19 February 2018

With regard to Planning Application R/55/16/HH for alterations to 84 North Lane, I wish to endorse and augment the Parish Council's objections thereto.

DWG. No. 1712081/PL/1

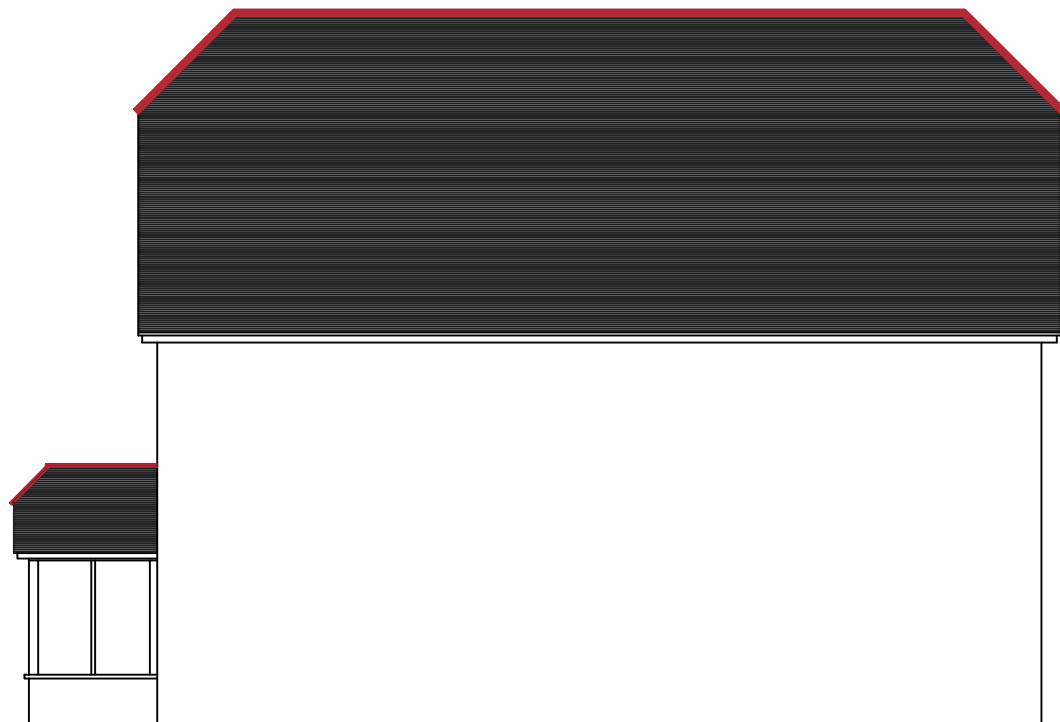
Not only would the mass and height of the building overbear and overshadow the adjacent properties, it would also be detrimental to the ambience of North Lane properties as a whole. During the 30 years I have lived here, front gardens have been turned into car parks, many trees have been removed and the property seeking this approval to enlarge in a most unprepossessing way has, during recent years, been an obvious business headquarters with its vans using the road as parking facilities.

I attach photograph showing how my kitchen's side window at 78 North Lane has an uninterrupted view across the gardens of 80 and 82 and beyond them enjoys a glimpse of picturesque old Rustington - i.e. of the very pretty roof on the south facing elevation of the old Farmhouse at No. 84, which is of coloured slate tiles surrounded by bright blue sky on a summer day.

It is bad enough that my home has been overshadowed by the new classroom building at North Lane School which has intruded on my home and ended my enjoyment and use of my garden. If 84's application is granted, we shall lose all trace of probably the oldest property in the road and I will also lose the only pleasant outlook I have left.
